Our ref: WA/2018/124752/02-L01
Your ref: 17/02534/OUT
Date: 18 June 2018

The construction of a business park of up to 60,000 sq.m (GEA) of flexible class B1(a) office / class B1(b) research & development floorspace; parking for up to 2,000 cars; and associated highways, infrastructure and earthworks. Land north of Bicester Avenue Garden Centre, Oxford Road, Bicester

We have reviewed the revised flood risk assessment, revision 04, dated 17 April 2018 and we have the following comments to make.

Drawing Title
Parameters Plan

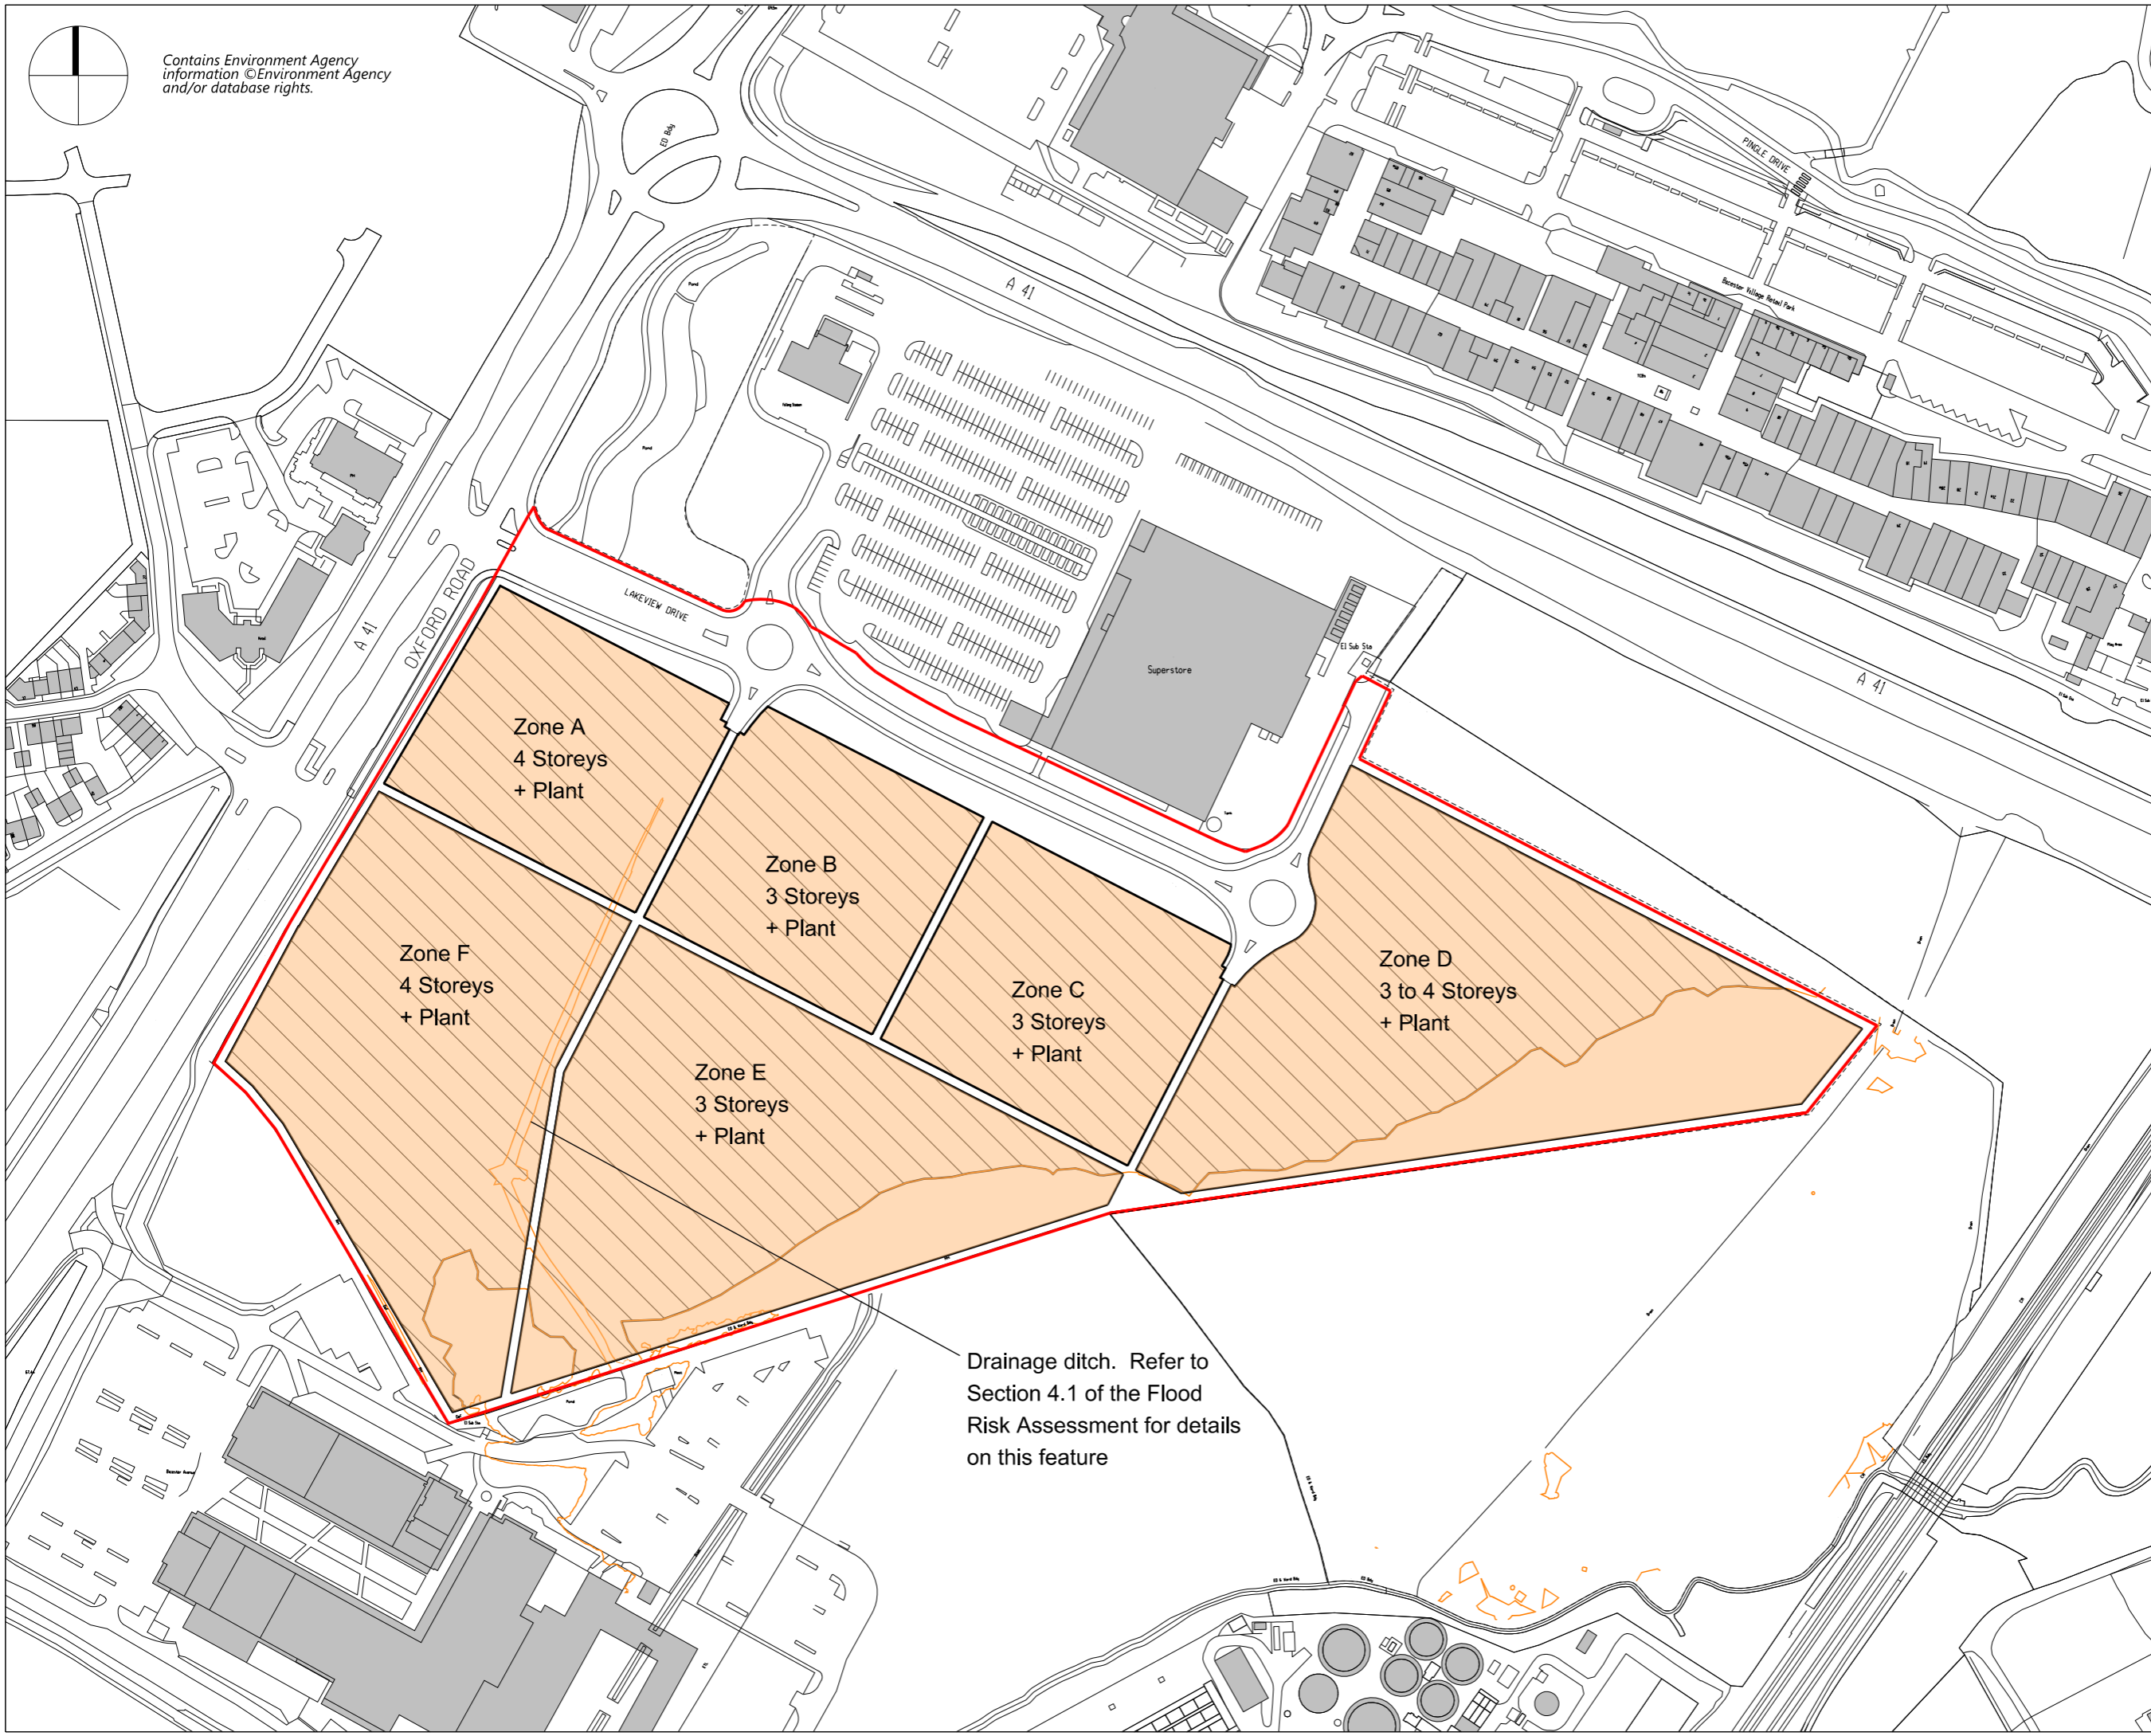
- finished floor levels set at the 1 in 100 year plus 35% climate change flood level with an additional 300mm freeboard, no lower than 64.83mAOD metres above Ordnance Datum.
- buildings located outside of the 1 in 100 plus 35% climate change flood extents.
- no raising of existing ground levels within the Functional Floodplain (i.e. within the 1 in 20 year flood extent)
